MORGAN AND MORECAMBE OFFSHORE WIND FARMS: TRANSMISSION ASSETS

Offshore Historic Environment Plan

December 2024
Rev: F02

MOR001-FLO-CON-ENV-PLN-0038
MRCNS-J3303-JVW-10020

Drawing Number:
BP-GBR-MORG-REG-0184

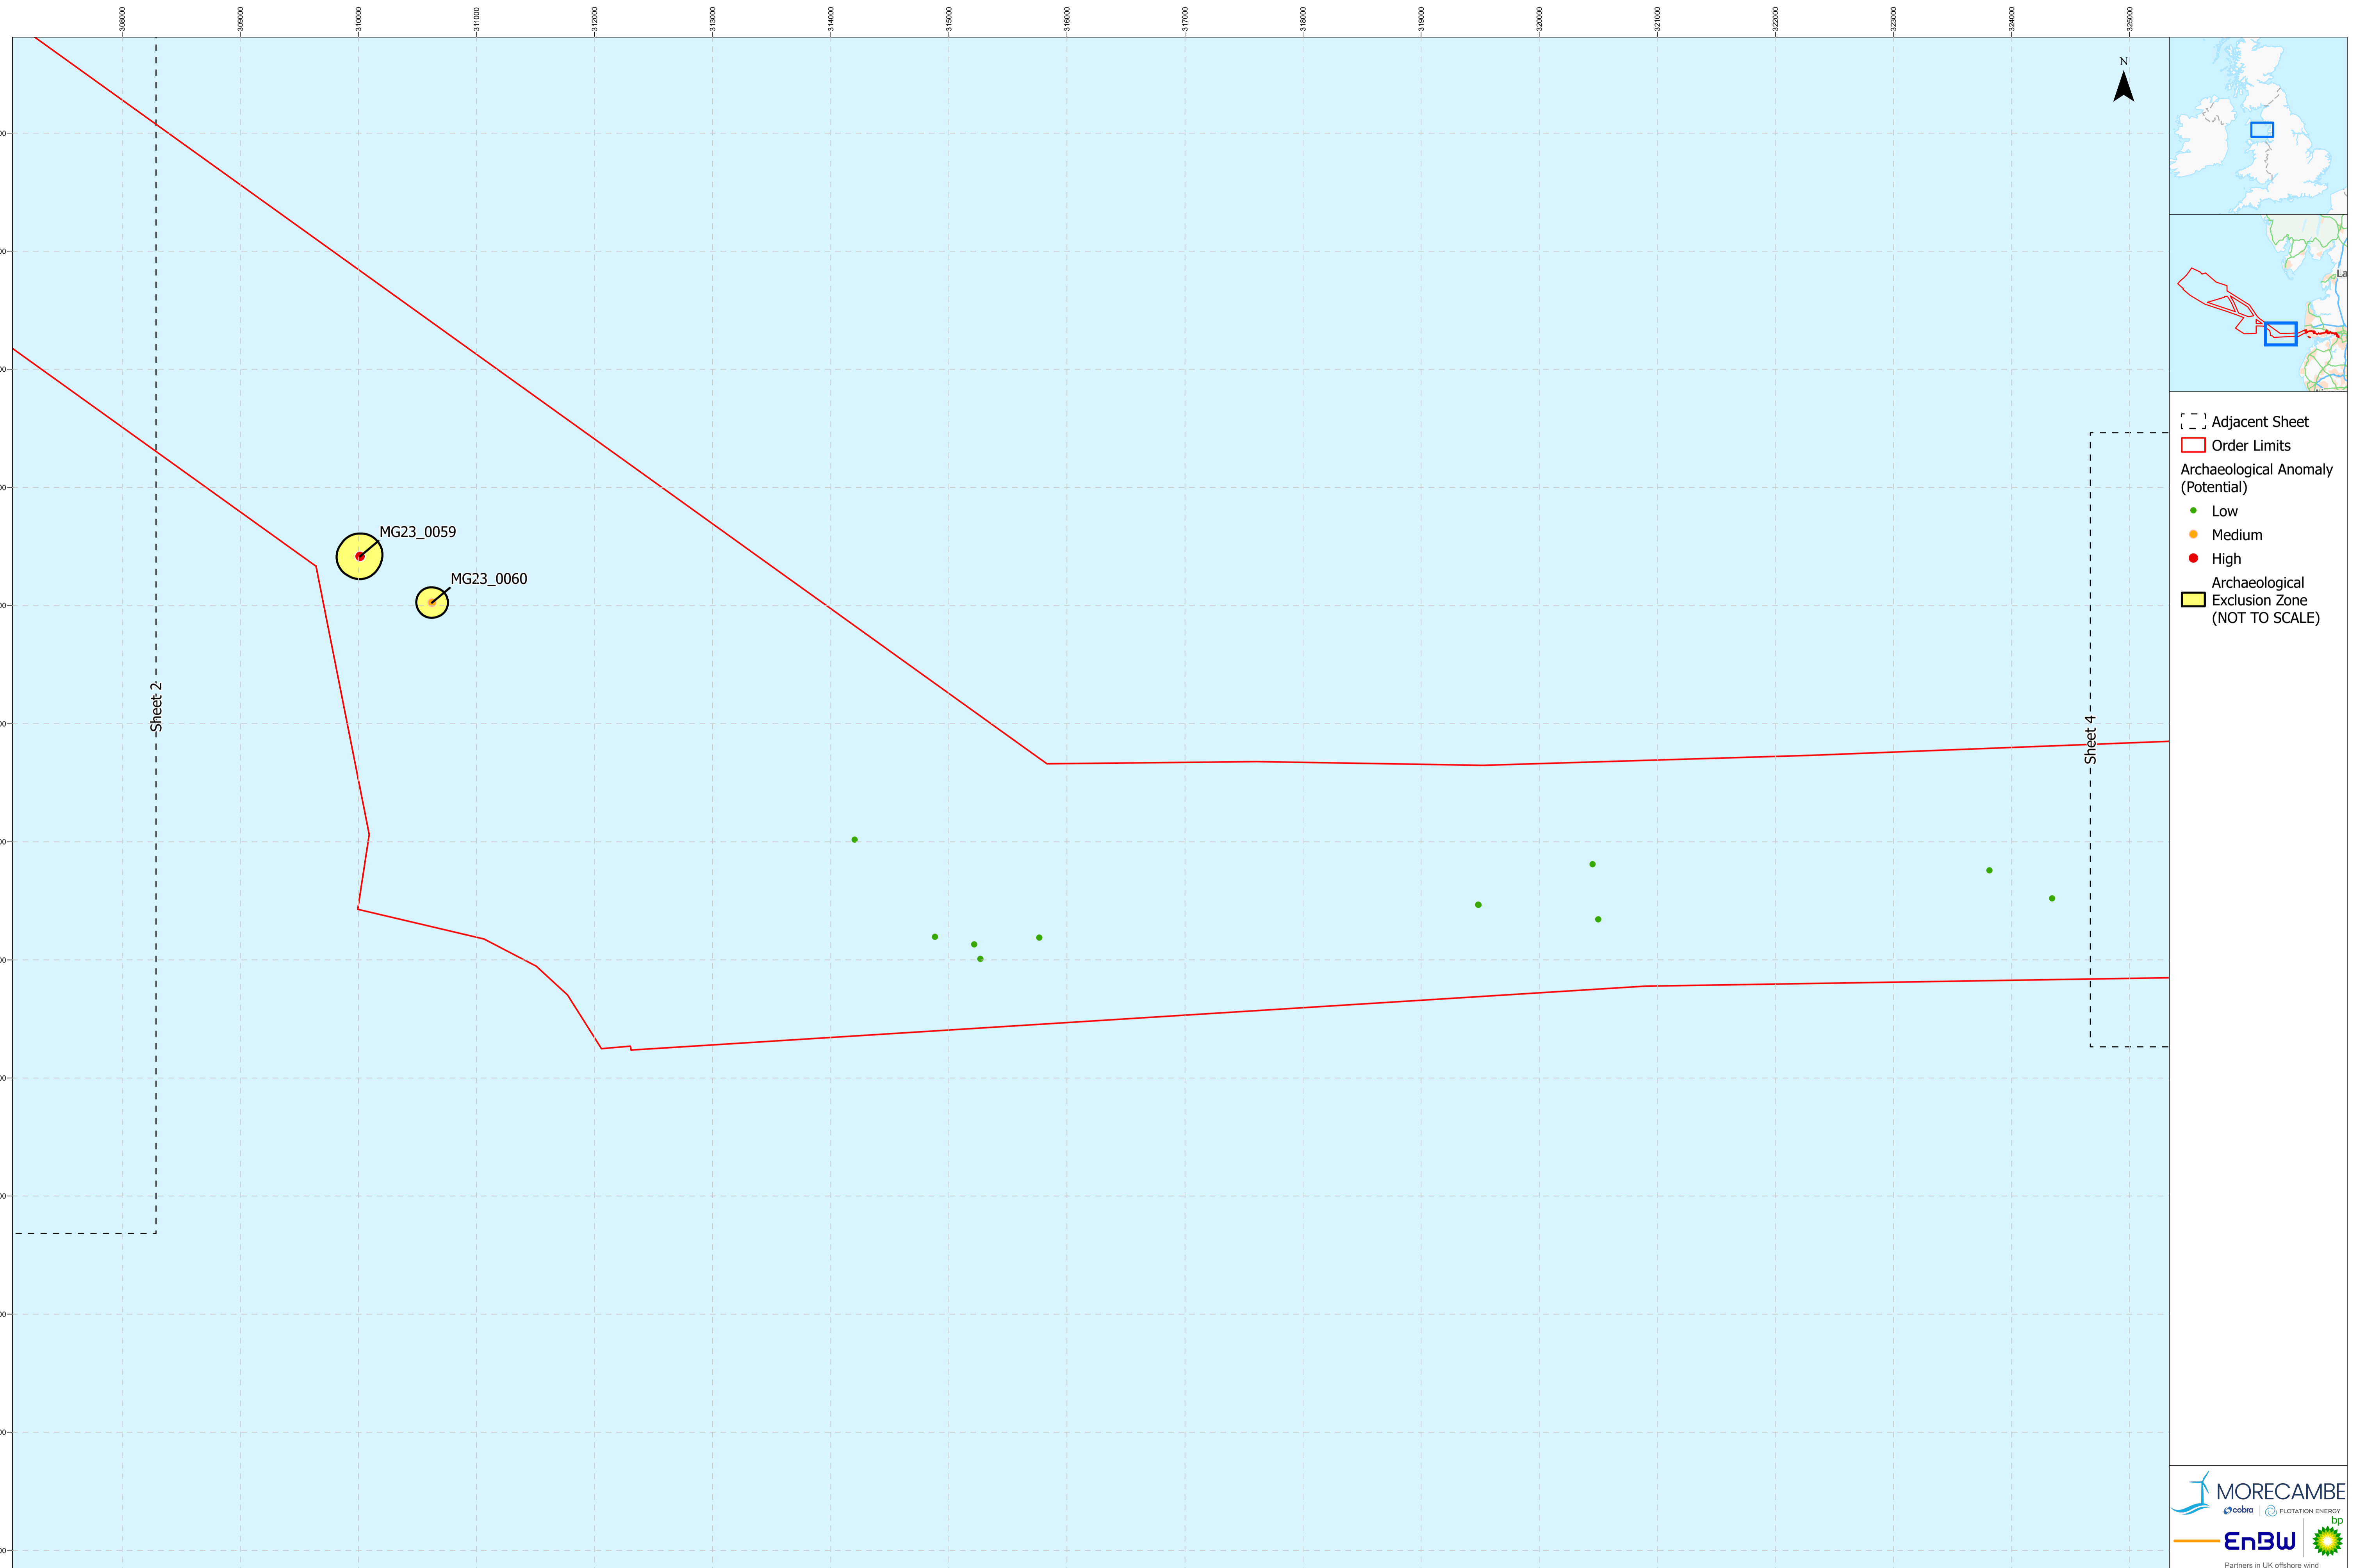
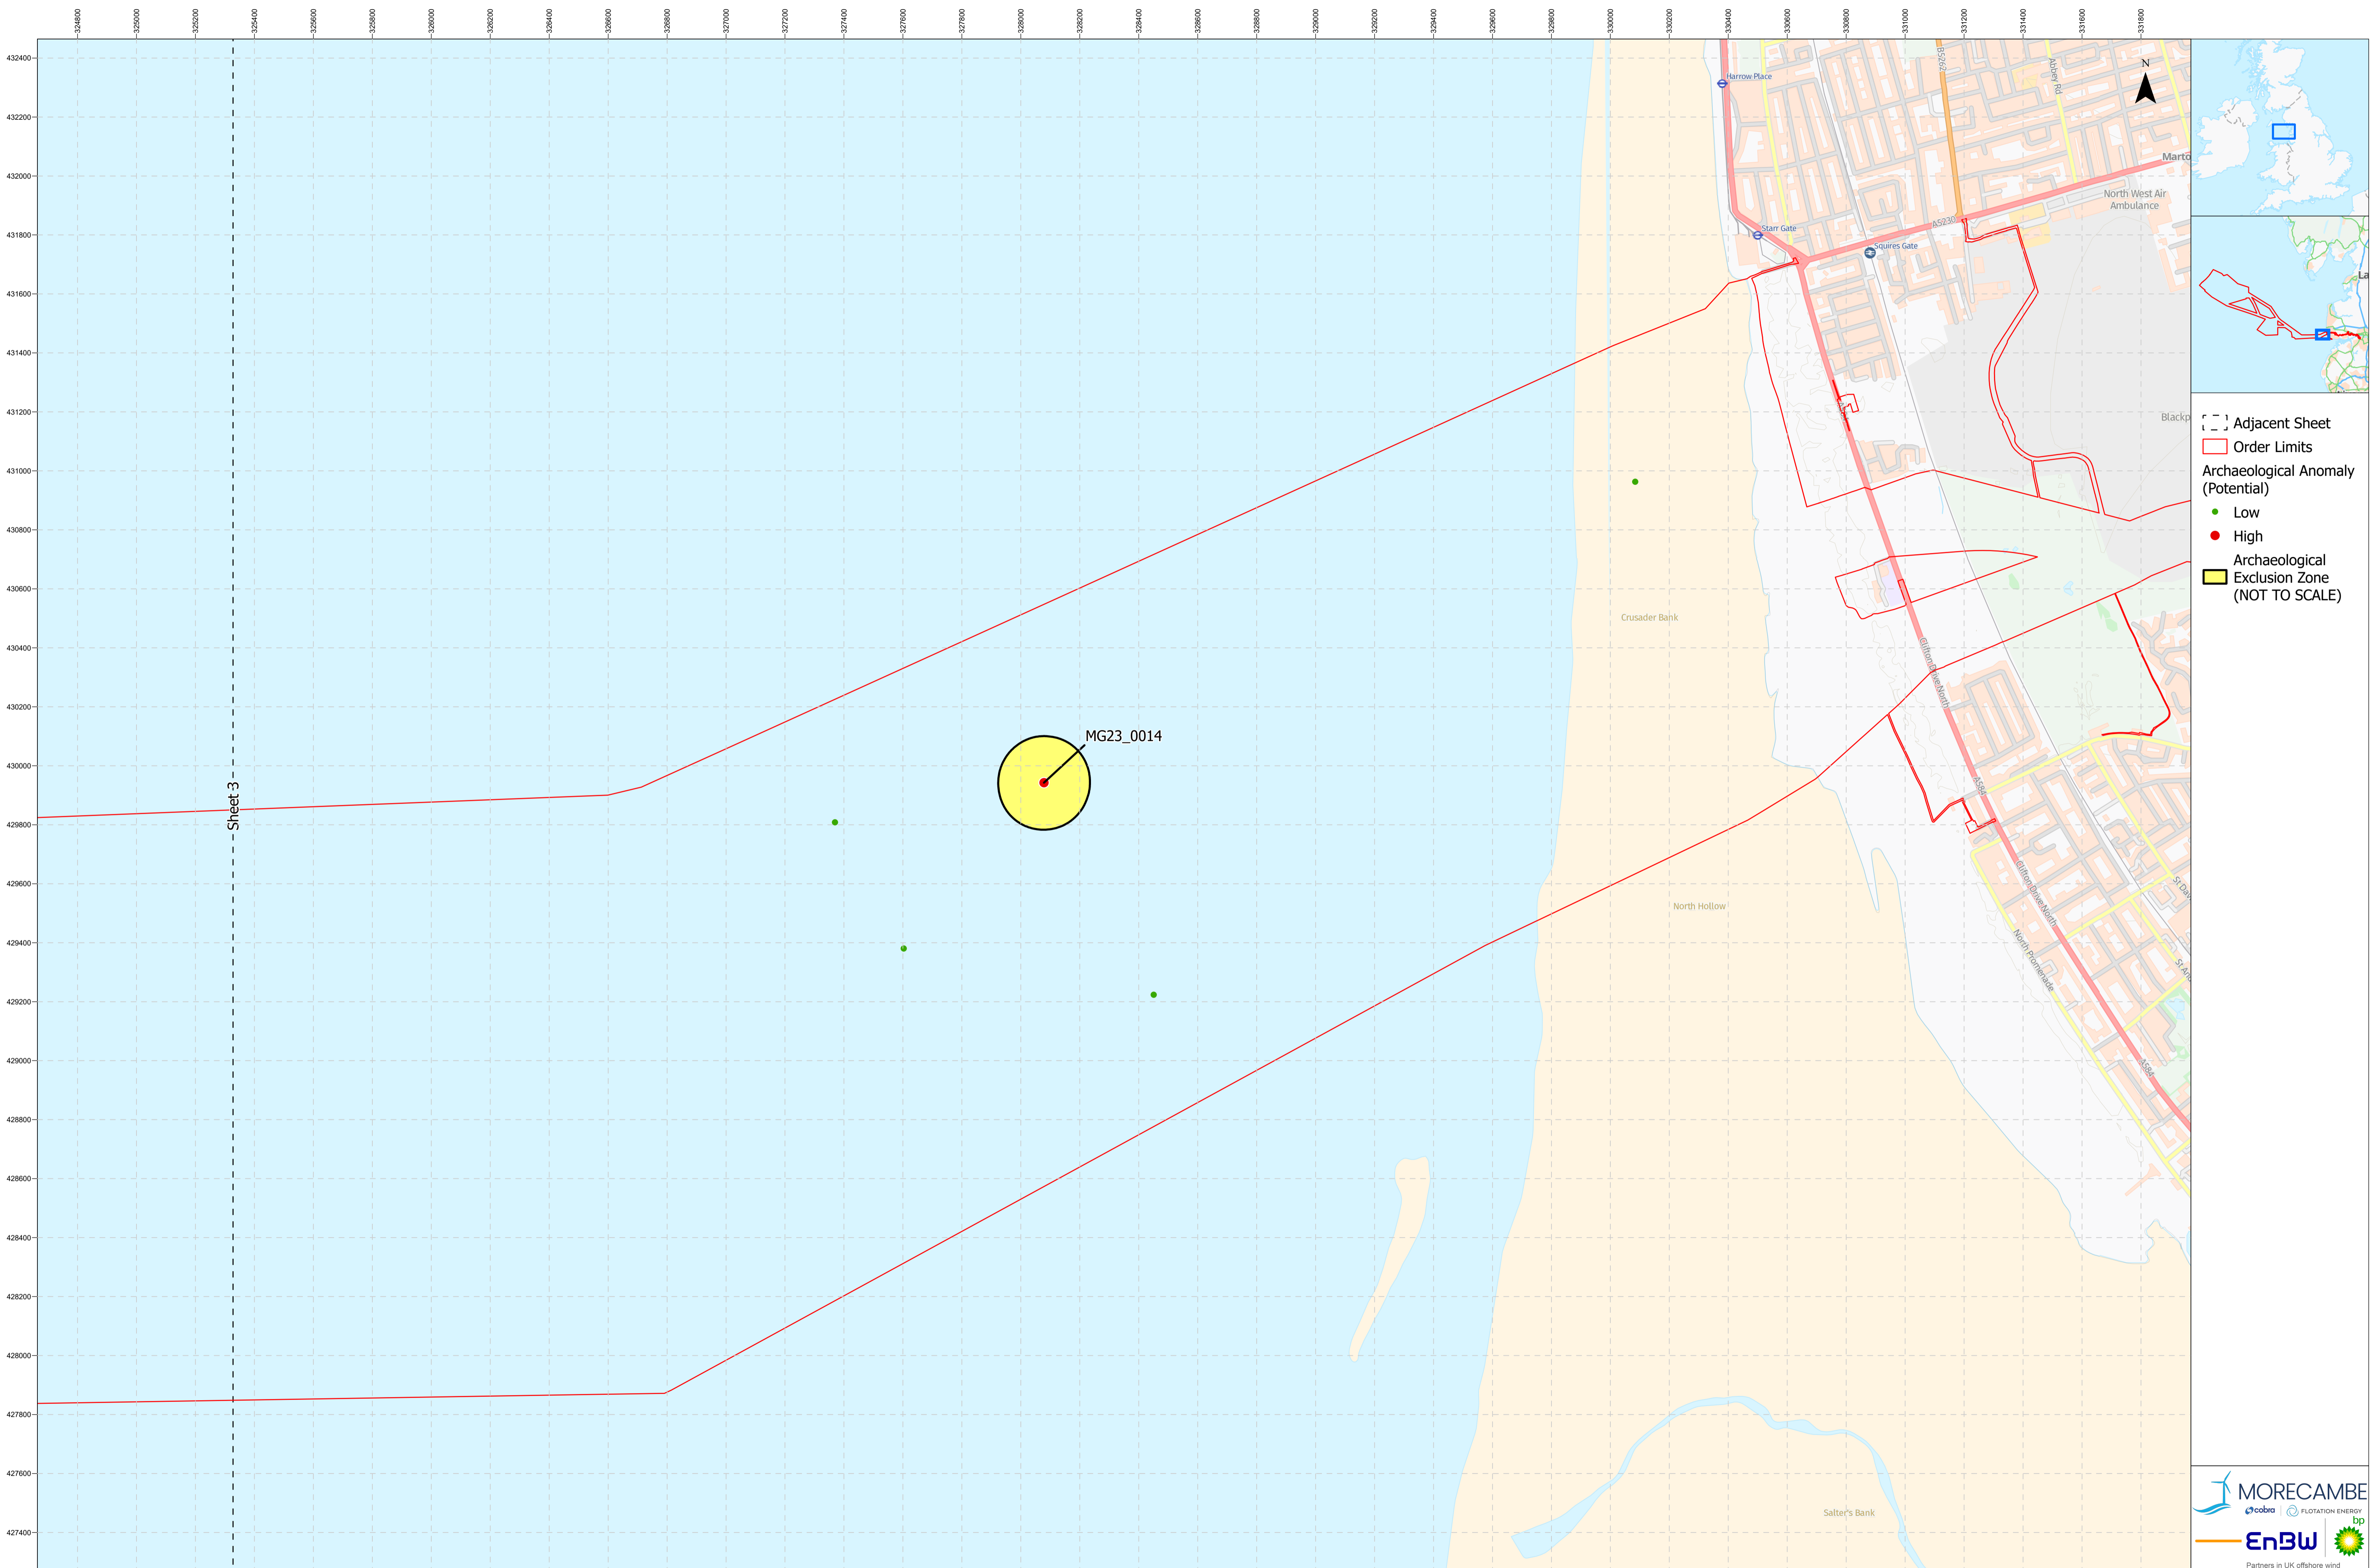
| Sheet Number | Change requested by | Change Made | Reason for Change | Revision | Submission deadline |
|--------------|---------------------|--|--|----------|---------------------|
| General | The Applicants | Labels describing the named wrecks have been added to Archaeology Exclusion Zone labels. Further information and descriptions for labels can be found within F2.8 Marine Archaeology Chapter of the ES, Table 8.16. | The labels added align with the information displayed and presented within the Environmental Statement and aid with cross referencing. | F02 | S51 advice update |
